## RHS comments to HE's response REP8-045.

1. This document responds to the Highways England REP8-045 document.
2. RHS does not seek to reply to each point made by HE.
3. The usual caveat applies i.e. where RHS has chosen not to seek to reply to a point made by HE, this does not mean that RHS agrees with the point being made.
4. This document follows the format used by HE's REP8-045.

Figure 1

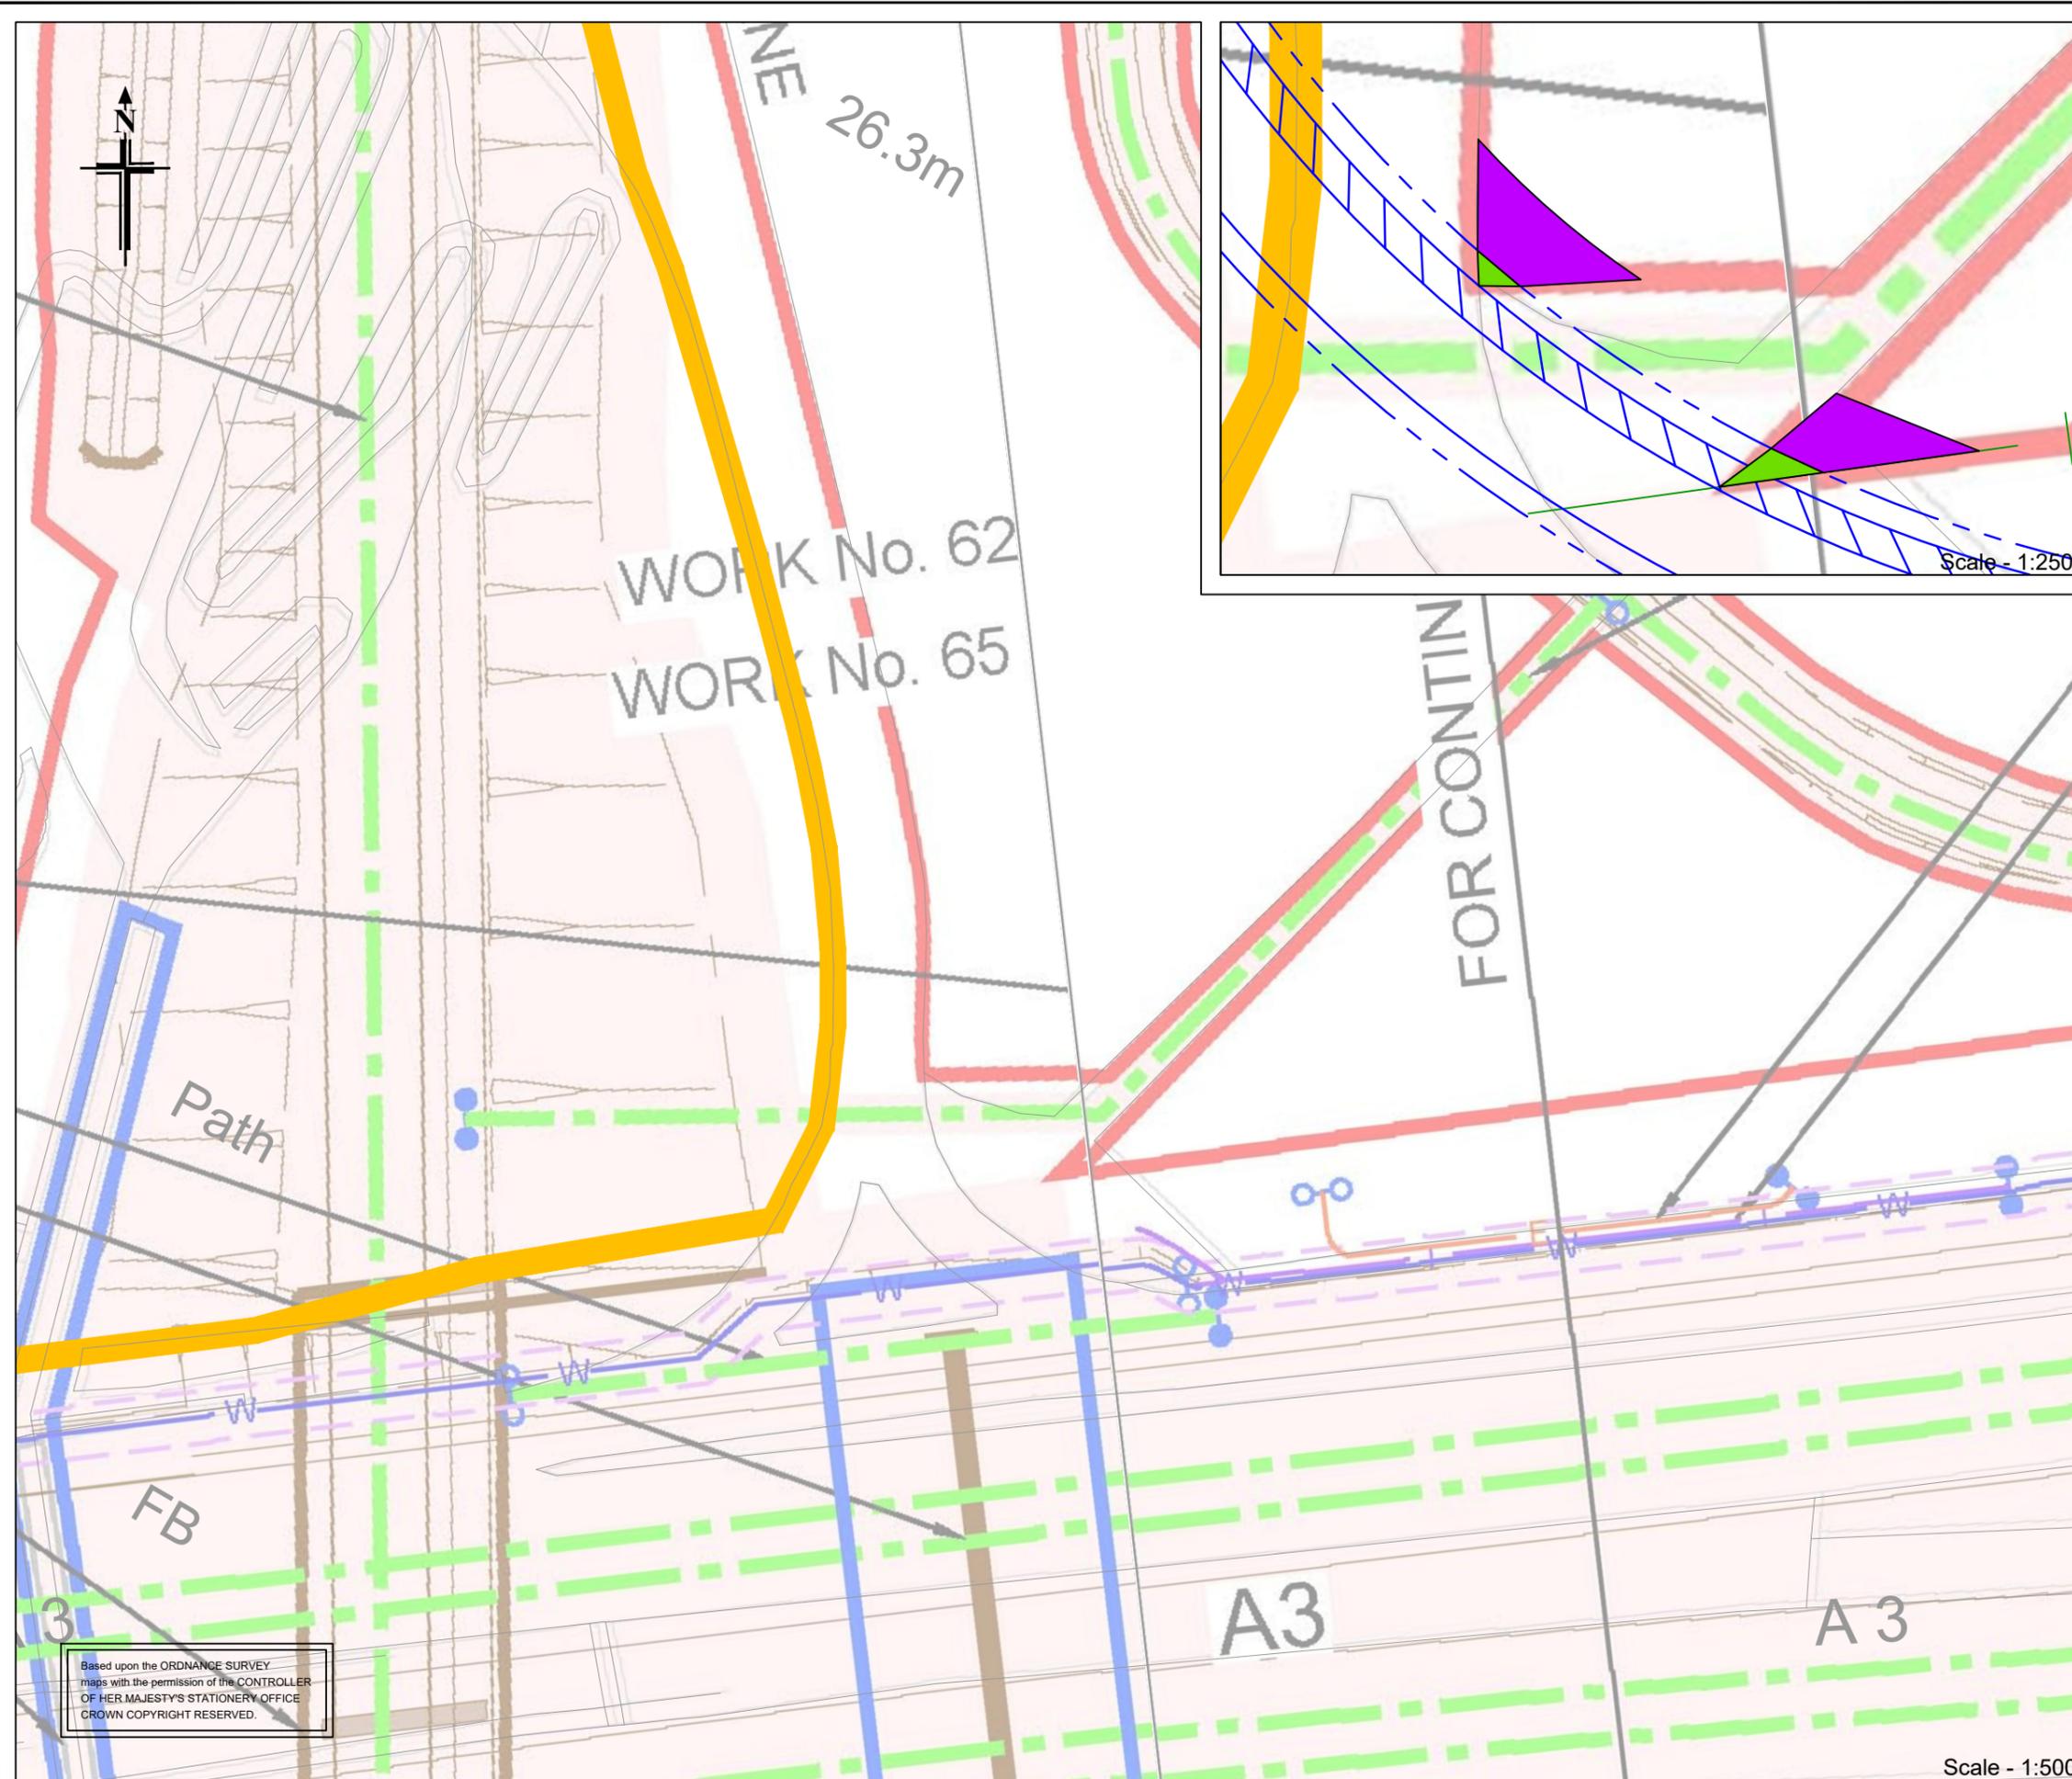
<p>the RHS Alternative Scheme at Wisley Lane (by contrast to the DCO Scheme) is 31.63m<sup>2</sup>. This additional SPA land impact is shown in Figure 1.</p> <p>3.63m<sup>2</sup> of SPA permanent land take amounts to an additional 0.00615% when compared to the 5.9ha (59,000m<sup>2</sup>) of SPA land take that is to be permanently lost to the DCO Scheme.</p> <p>28m<sup>2</sup> of temporary land take amounts to an additional 0.032% when compared to the 8.7ha (87,000m<sup>2</sup>) SPA land take that is to be temporarily taken by the DCO Scheme. The overall total additional land take (both permanent and temporary) from the SPA as a result of the RHS Alternative Scheme is 31.63m<sup>2</sup>. This amounts to an additional 0.02% of the SPA when compared to the 87000 + 59000 = 146,000m<sup>2</sup> to be taken under the DCO Scheme. This cannot be considered material in any way.</p>		
---	--	--

<p>Notwithstanding the tiny scale of the additional SPA land impact of the RHS Alternative Scheme by comparison to the DCO Scheme, the RHS Alternative Scheme will have no additional impact on the integrity of the SPA through the land impact pathway. This is because:</p> <p>(i) The additional 31.63m<sup>2</sup> area of SPA land to be affected under the RHS Alternative Scheme consists of the road verge which is already occupied by street furniture.</p> <p>See the photos in Figures 2 and 3 below.</p> <p>(ii) This area is therefore part of the SPA “site fabric” as defined by Natural England as “land and/or permanent structures present within a designated site boundary which are not, and never have been, part of the special interest of a site, nor do they contribute towards supporting a special interest feature of a site in any way, but which have been unavoidably included within a</p>		
--	---	--	--
